12 October 2011

RE: AIR QUALITY IMPACTS OF PROPOSED FURTHER MODIFIED PREFERRED PROJECT TO DELLARA PTY LTD V MINISTER FOR PLANNING & PENRITH CITY COUNCIL – LAND AND ENVIRONMENT COURT CLASS ONE PROCEEDINGS 10928 OF 2010 – RESPONSE TO MINISTER

Figure 2.18  
 INDICATIVE FINAL LANDFORM

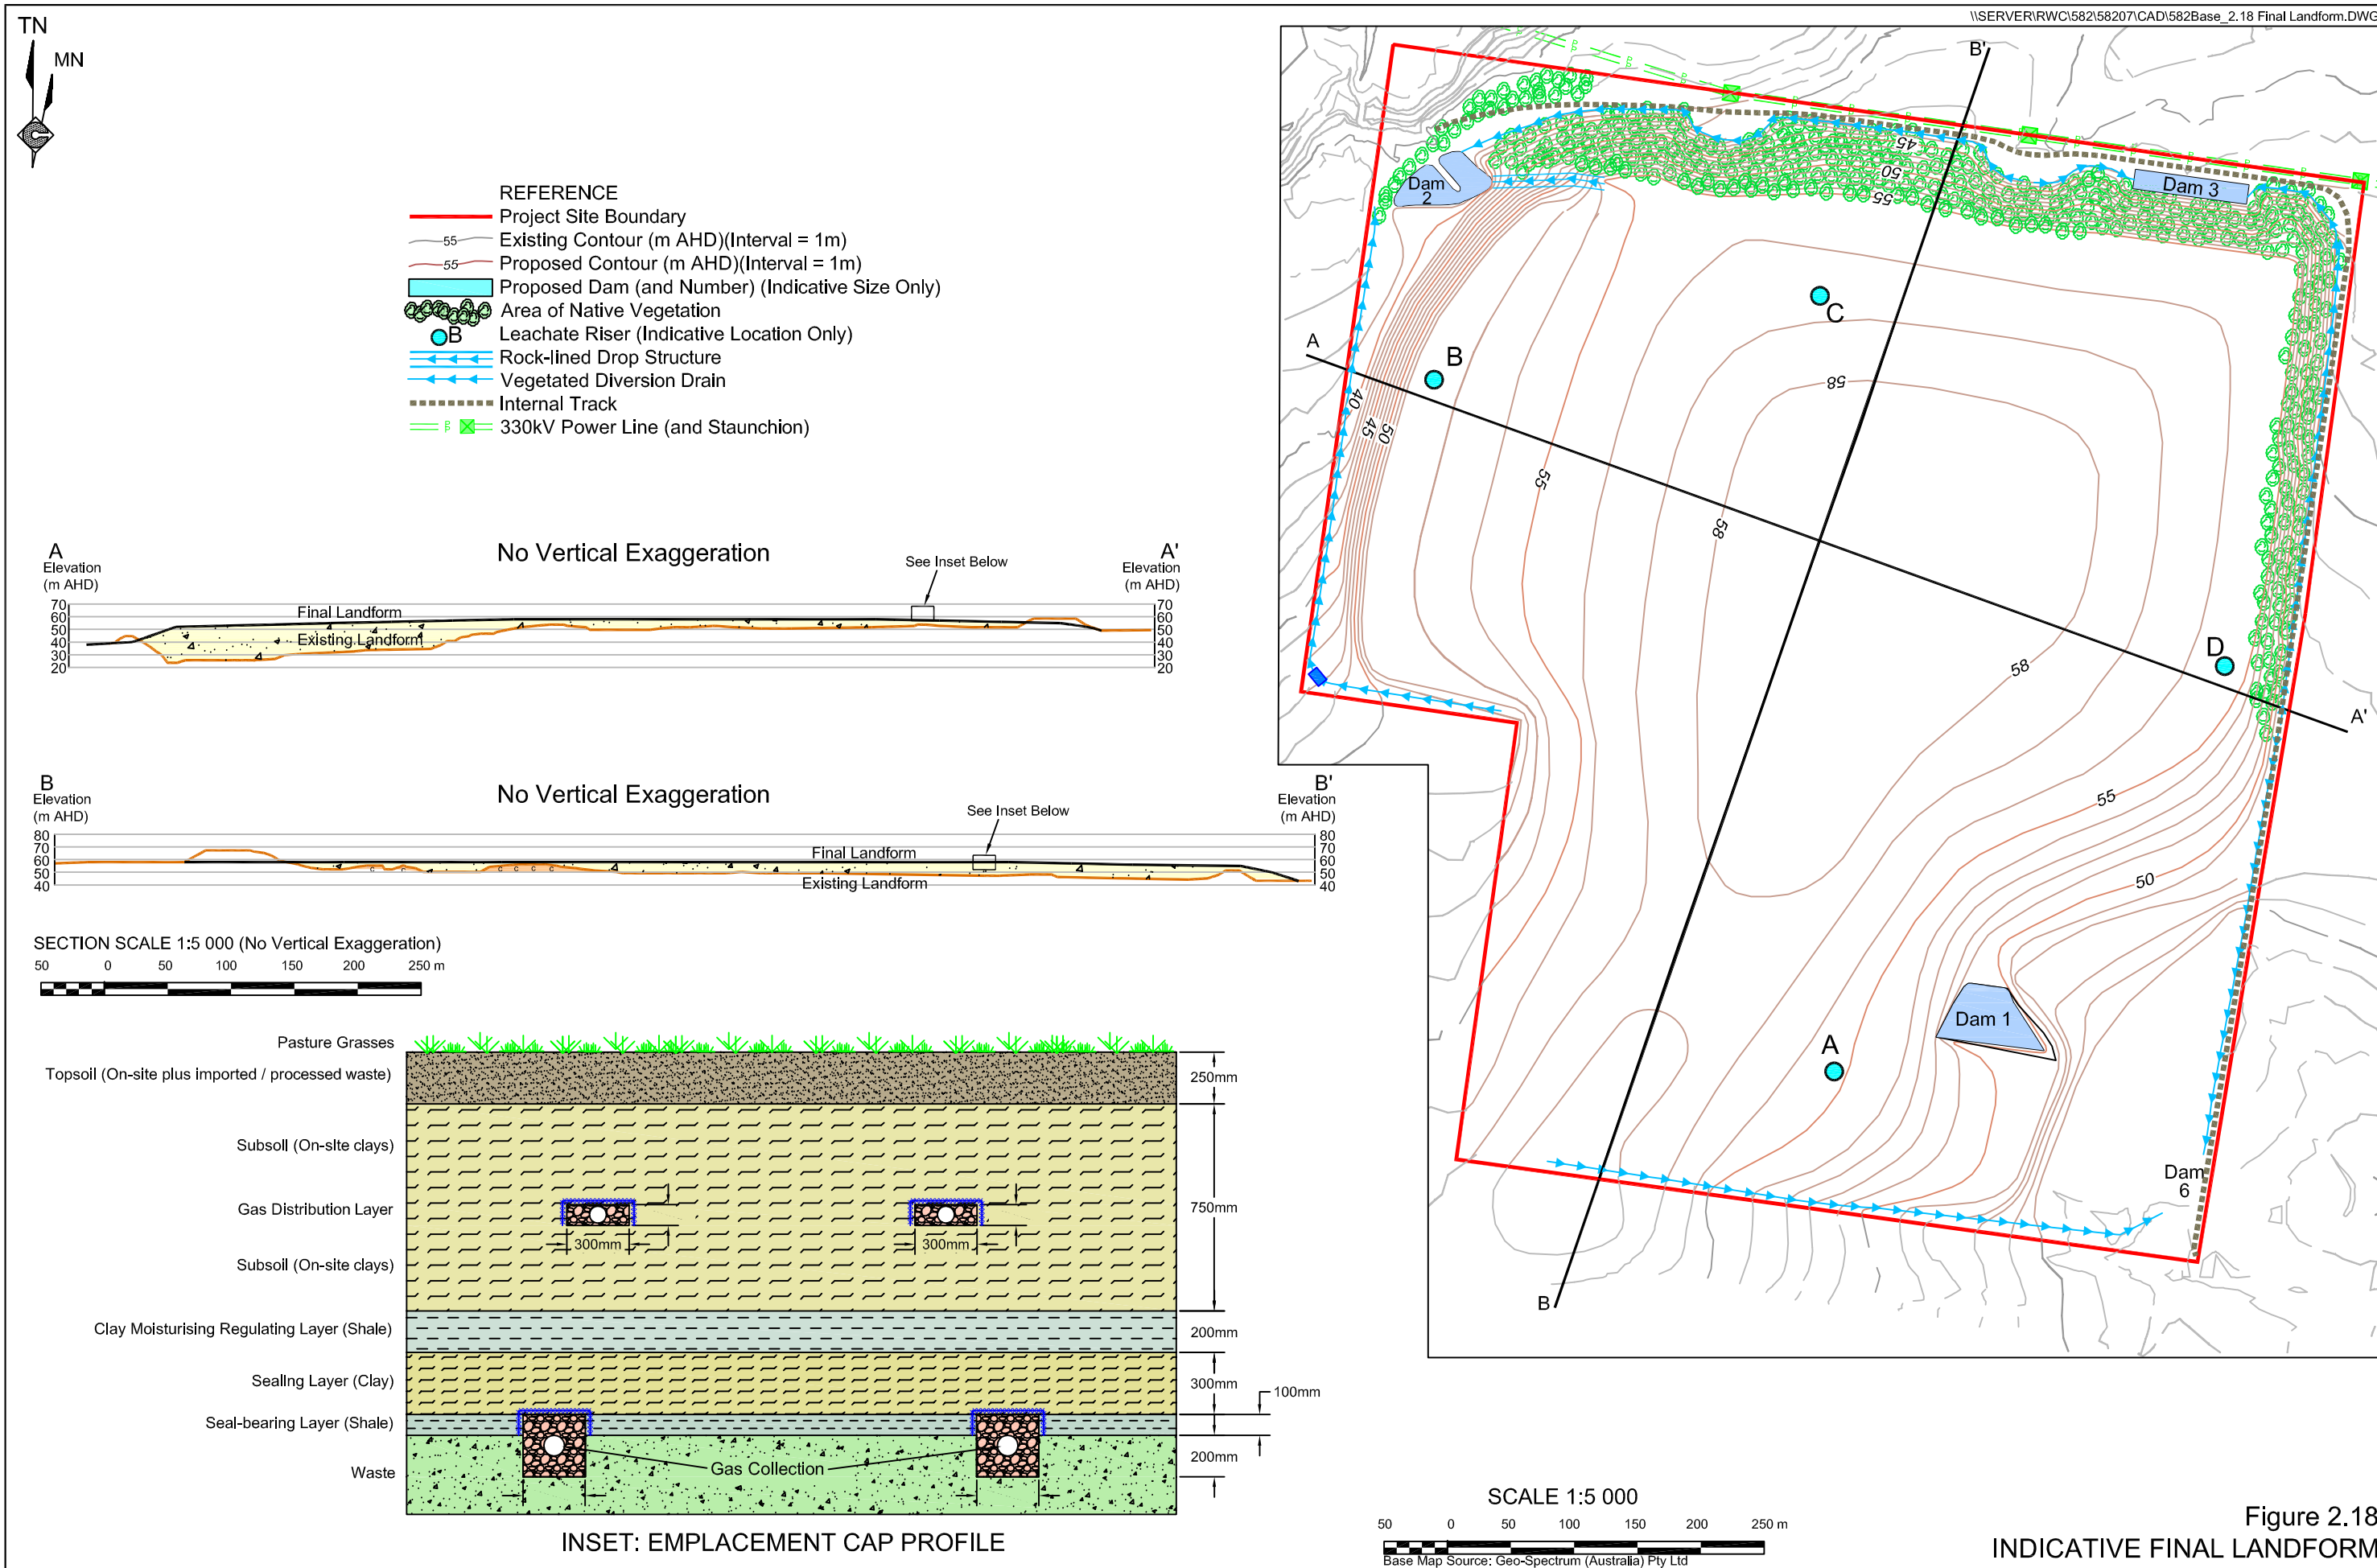
1. *Reduction in height of the final landform:*

- a reduction in the finished level of the northern face from 55m AHD to approximately 44m AHD, 3-4m above the pre-existing ground levels (the interim acoustic mound would be at 53m AHD for acoustic purposes);
- a reduction in the elevation of the northern face to a 5% slope profile to integrate more closely with the existing ground level; and
- the substantial removal of the southwestern, southern and eastern bund walls and the forming of part of the final landform during the course of the project, to reduce visual impacts.

This modification is related only to the final landform of the site and as such is not relevant to the Air Quality Impact Assessment (AQIA).

Whilst there may be potential for more material to be moved, these operations would take place over a relatively short period and as such any dust generation would be easily managed, in manner akin to any other construction activity.
